## CITY OF PORTLAND

August 31, 1999

RE: Pool permit at 29 Hillcrest Avenue - R-3 zone - 260-C-022

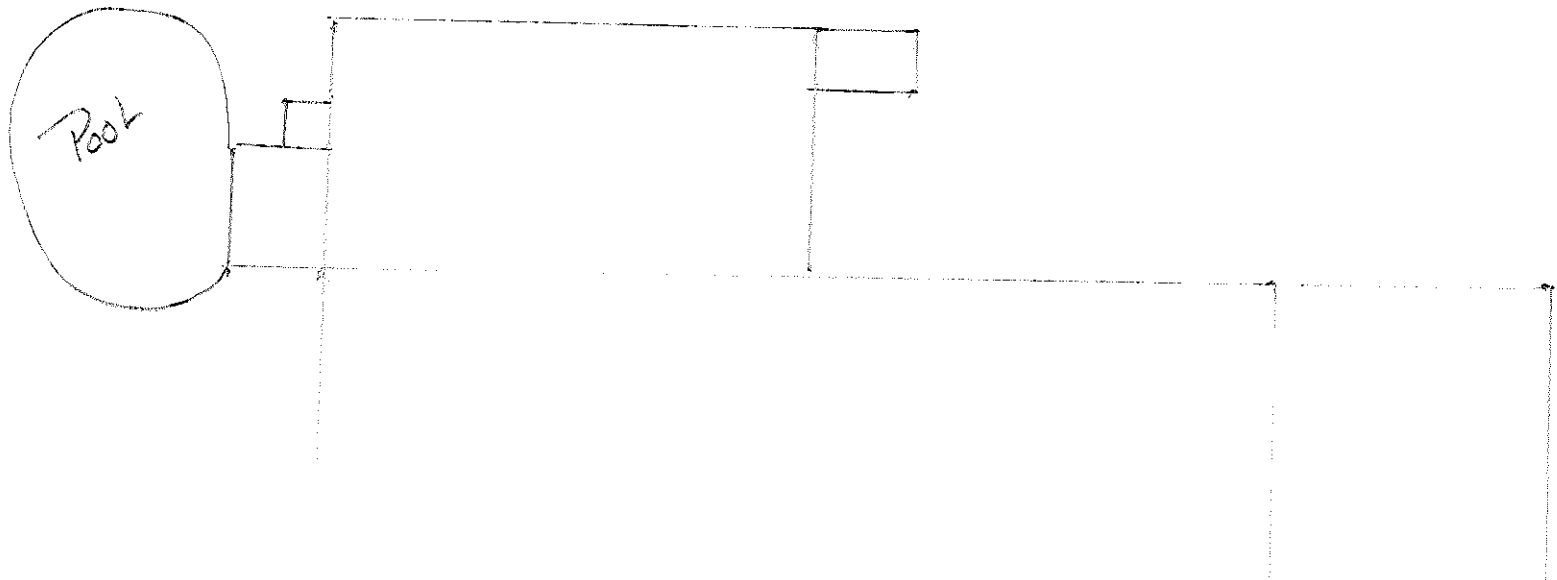
Your plans show that your pool will only be six (6) feet from your principal structure. I can not issue your permit until you can show me that you can meet the required setbacks. If you can not meet the required setbacks, you have the right to appeal. These types of appeals are very, very difficult to get from the Zoning Board. If you wish to appeal, I will be glad to forward the appropriate information to you so you will know what to submit. You have 30 days from the date of this letter in which to appeal.

9/9/99  
owner will move  
pool so 10' from  
principal structure  
will be met  
D
